Office of  
Environment  
& Heritage

Our Ref: DOC18/824482  
Your Ref: SSD 9575

**Re: Public exhibition of State Significant Development Application for New Tweed Valley Hospital (SSD 9575)**

## Attachment 1: Detailed OEH Comments – New Tweed Valley Hospital (SSD 9575)

## TREE REMOVAL AND PRESERVATION PLAN

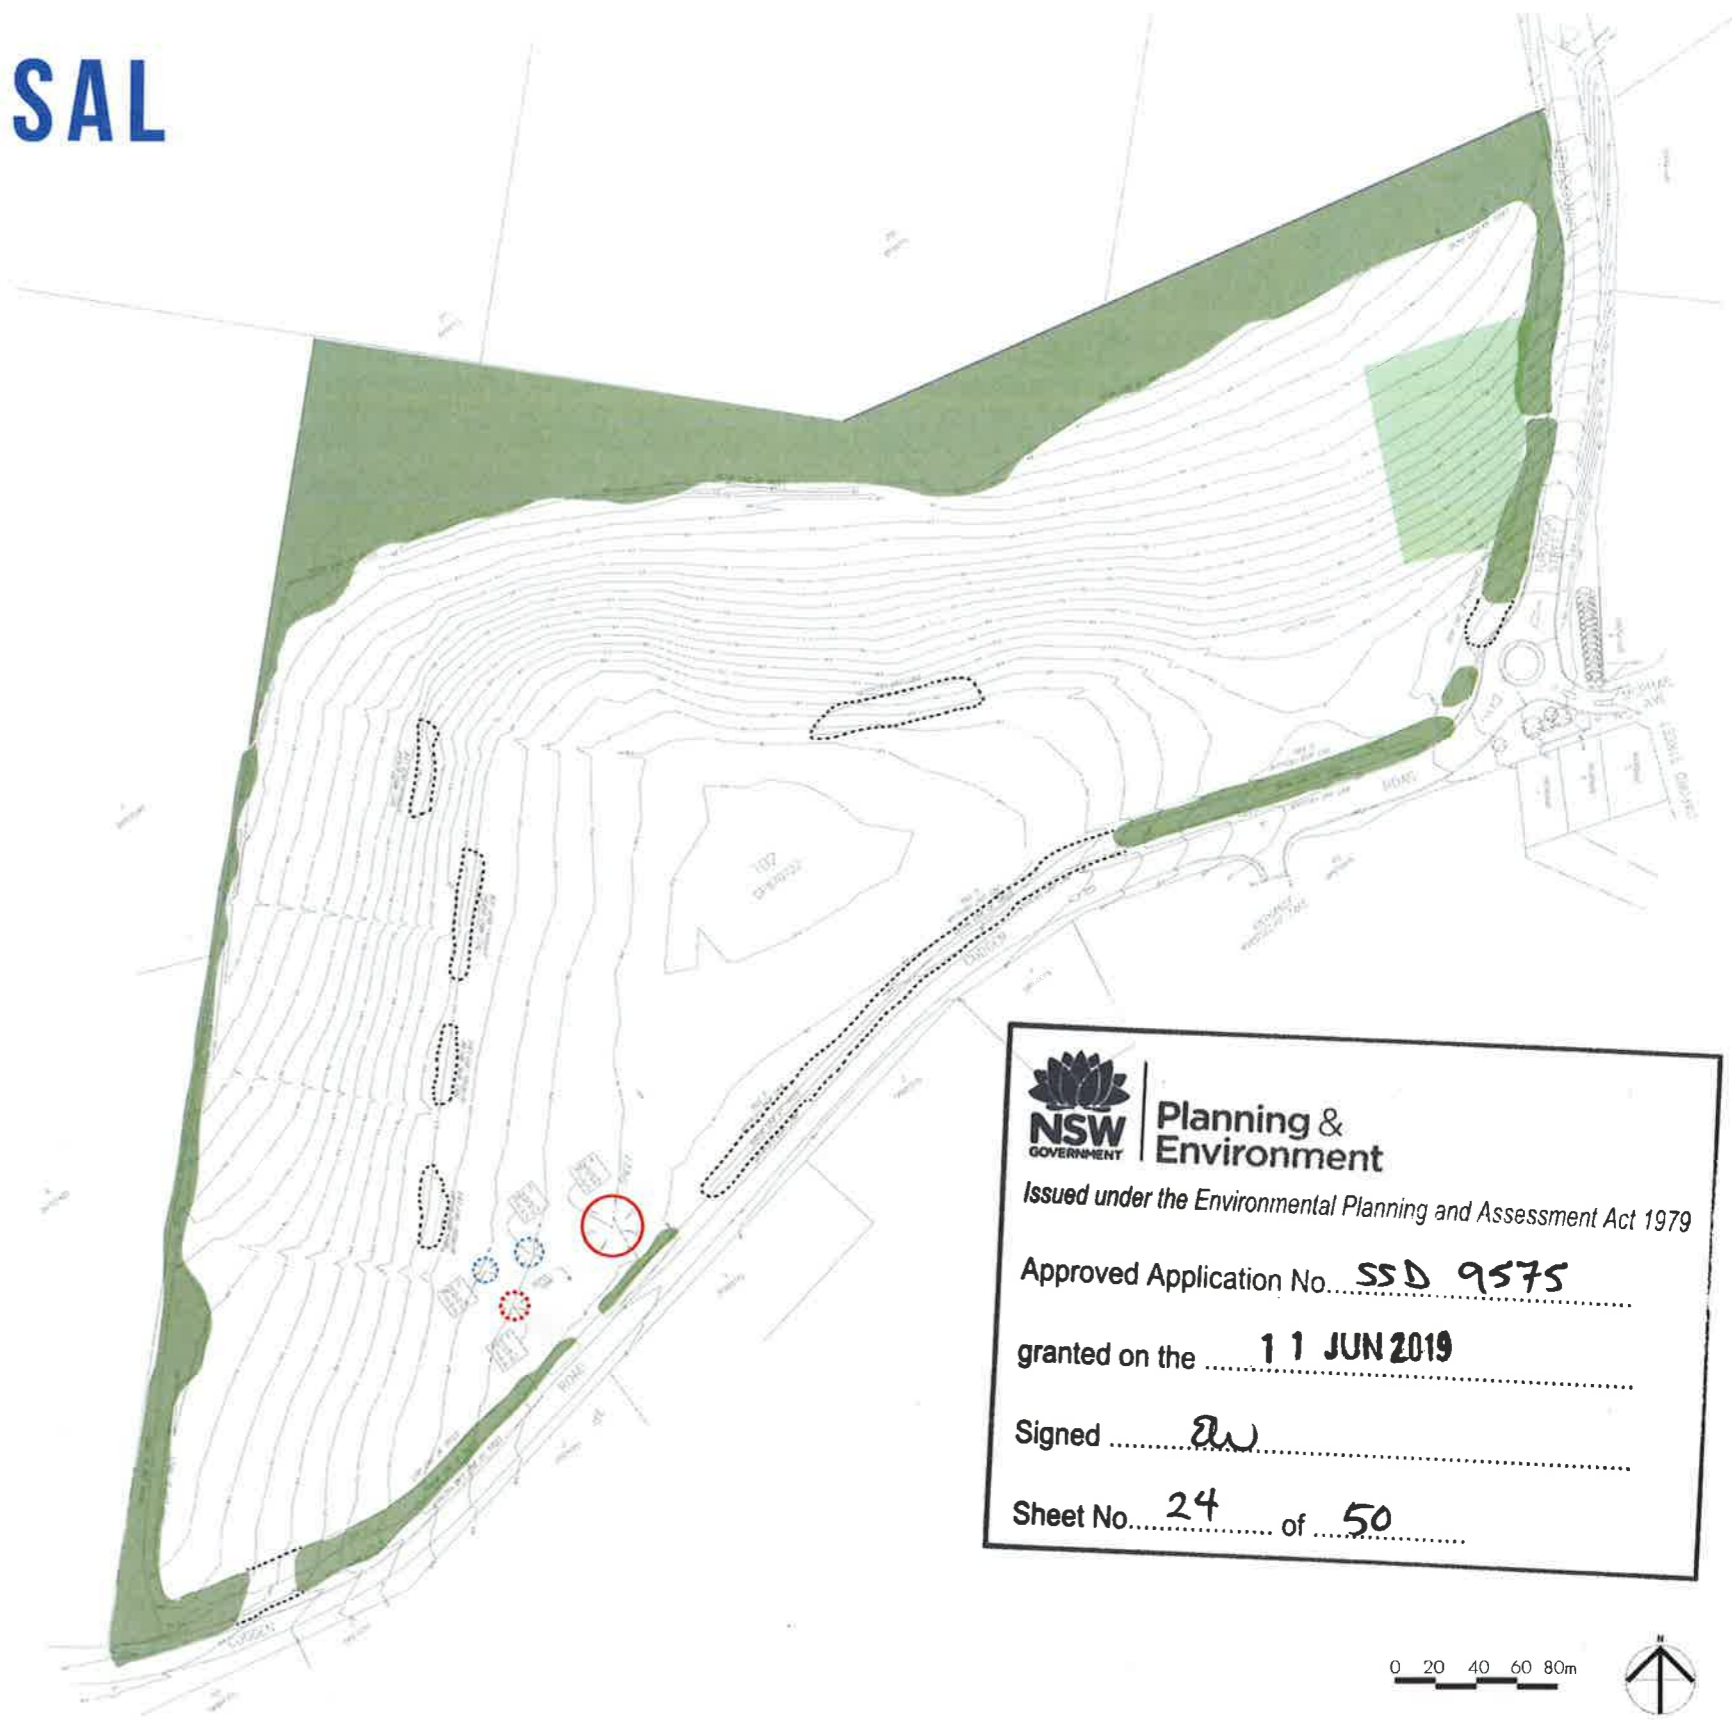
The BDAR states a 100m buffer is to be retained to the existing vegetation except zone 5, as well as one *Ficus obliqua* near the existing residence. A 10m wide vegetated buffer is also proposed to be retained and enhanced along the property boundaries, but this is not continuous and at one point along the boundary is within the 50m wide bushfire Asset Protection Zone (APZ) to the proposed hospital building.

The OEH has undertaken its assessment on the understanding that no vegetation will be required to be cleared either in the development site or adjoining properties to establish the required APZ. It is noted that APZs cannot be required on adjoining properties.

SEDIMENT BASIN SCHEDULE

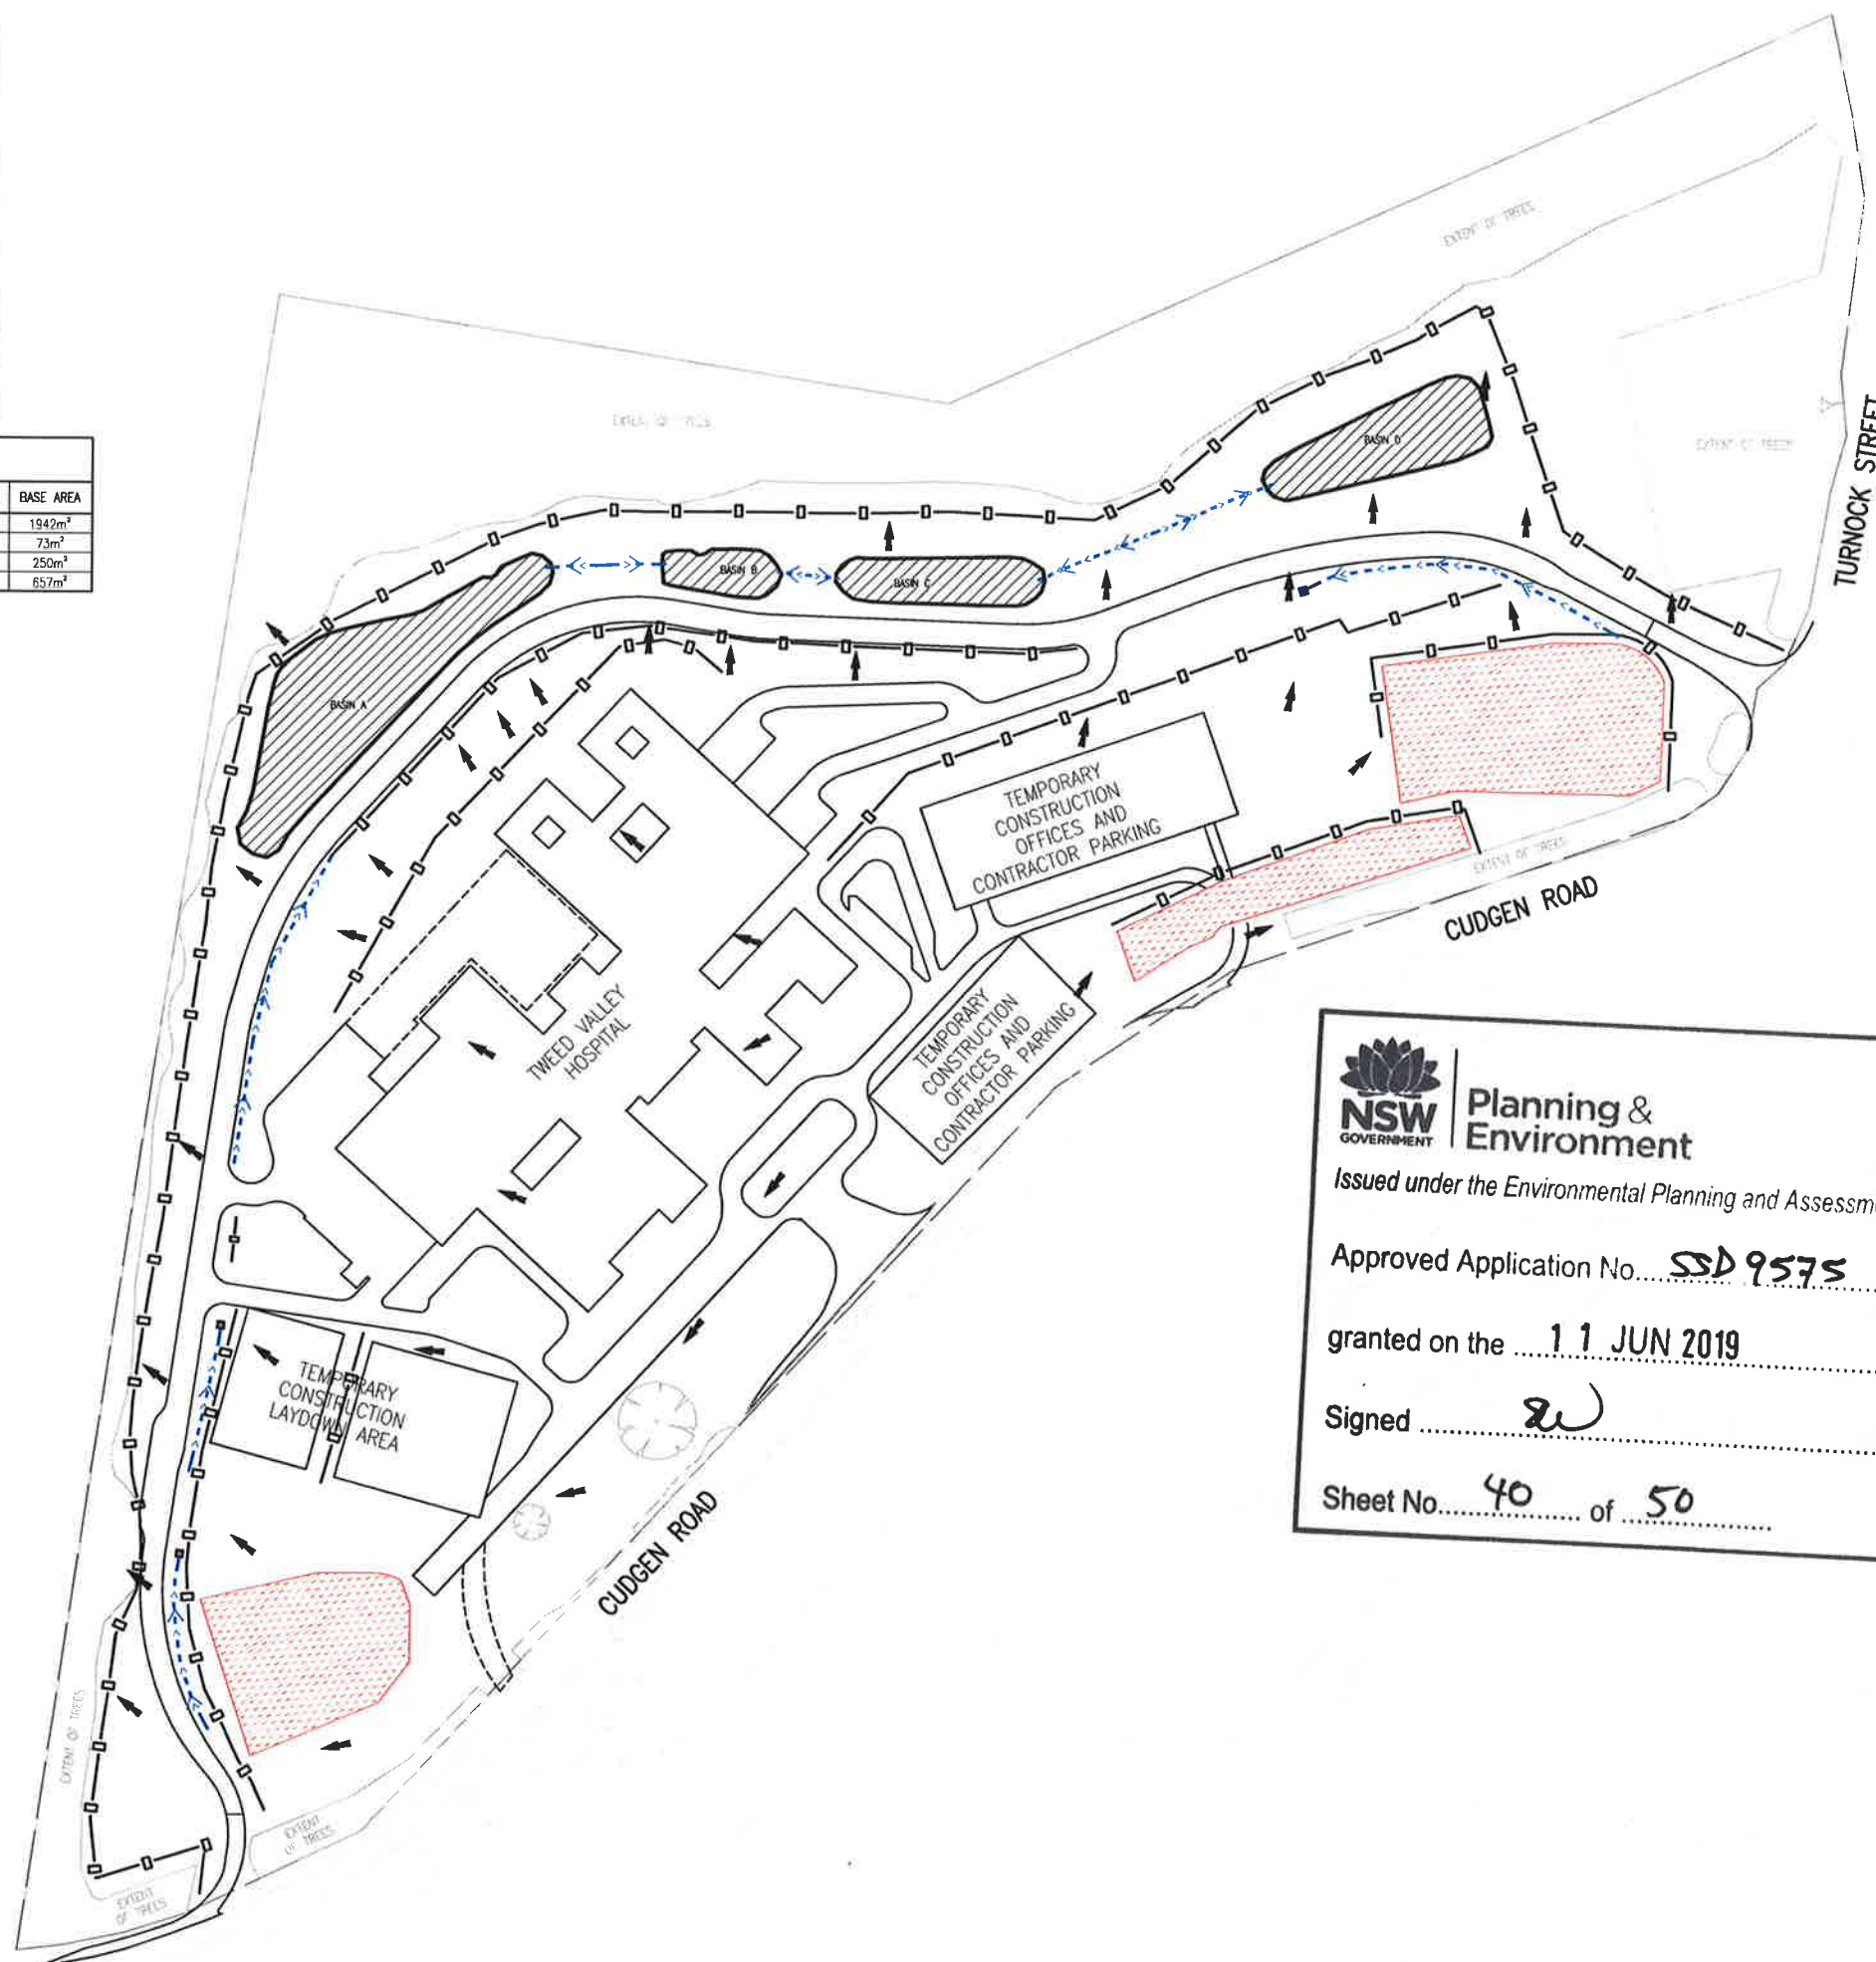
As the BDAR notes the stormwater management system is at a concept development stage only. The preliminary works for the project include sediment basins as described in Stage 1 Early Works AR-DWG-10-100 by Bates Smart. No buffers are provided between the sediment basins and the wetland vegetation. The sediment basins are described as bio-retention swales in the MUSIC modelling but there are insufficient details on their design and management. The Landscaping Proposal does not map or describe these basins or any vegetation treatment for them. It is also not clear how bio-retention basins will be consistent with the bushfire protection measures.

In addition to the considerations under the BAM, the EIS should demonstrate how the Coastal SEPP has been addressed including considering the impacts on the proximity areas of stormwater detention and the design, construction and maintenance of sediment ponds.
